Marge Schmuckal - application #2013-01789 - 30 Salem Street

From: Marge Schmuckal
To: gregory.davis54@yahoo.com
Date: 8/15/2013 10:23 AM
Subject: application #2013-01789 - 30 Salem Street

FRONT AND REAR ELEVATIONS

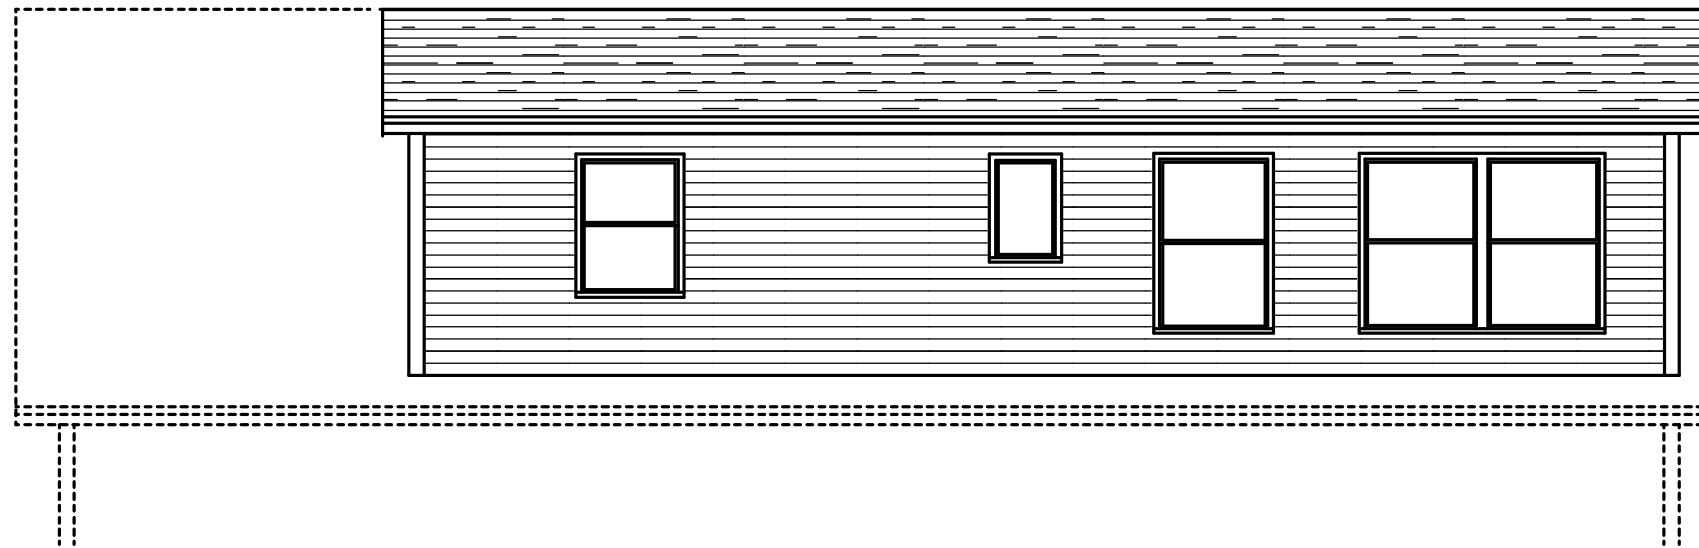
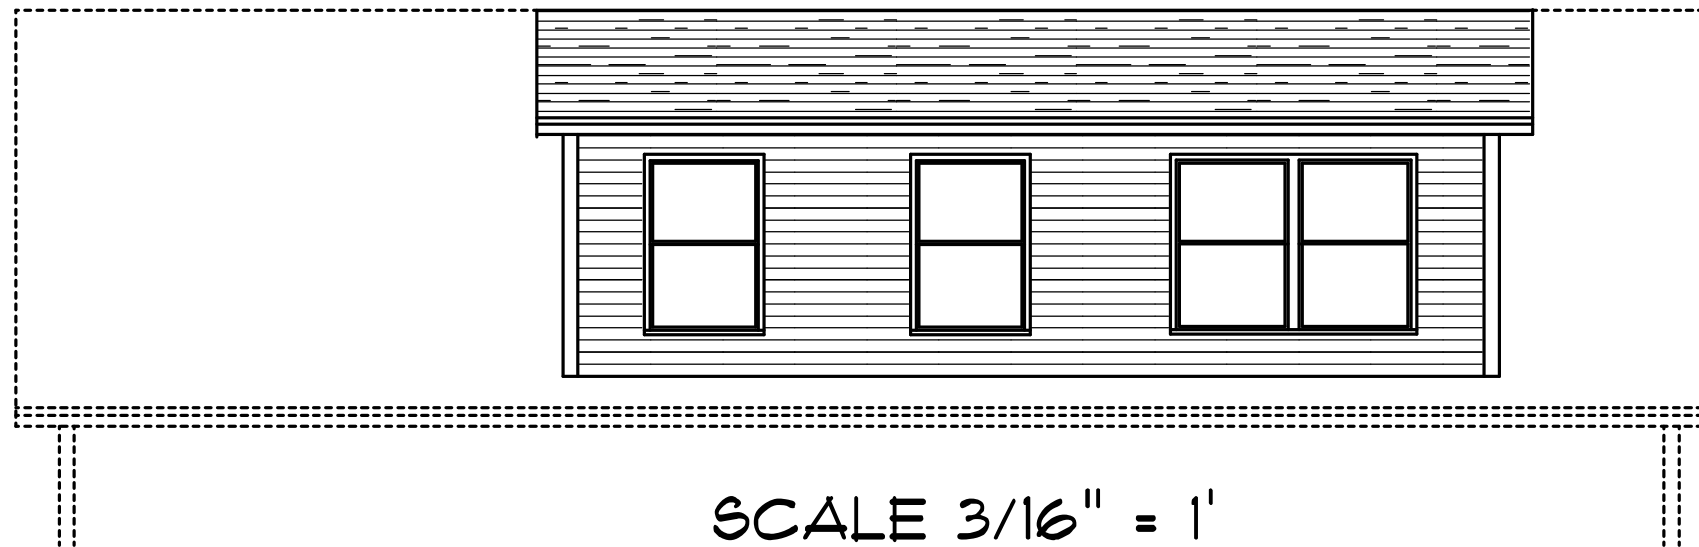
I am in receipt of your permit to put a dormer on the rear of 30 Salem Street. Presently I can not review your application for Zoning because your plans are not scaleable. Our requirements for building plans submittals must have a bar scale on the plans in order to calibrate our scaling program. I can not scale as given on the plans. I also did not receive a plot plan showing setbacks. So I am assuming that the current building is legally nonconforming for setbacks. If the building does meet setbacks, then I won't have to go thru a lot of calculations to determine compliance. A required plot plan submittal would have helped me determine that at the get-go.

Please supply the above information so that I can do my review. Your permit is on hold until I receive that information. If you have any questions, please call me at 874-8695.
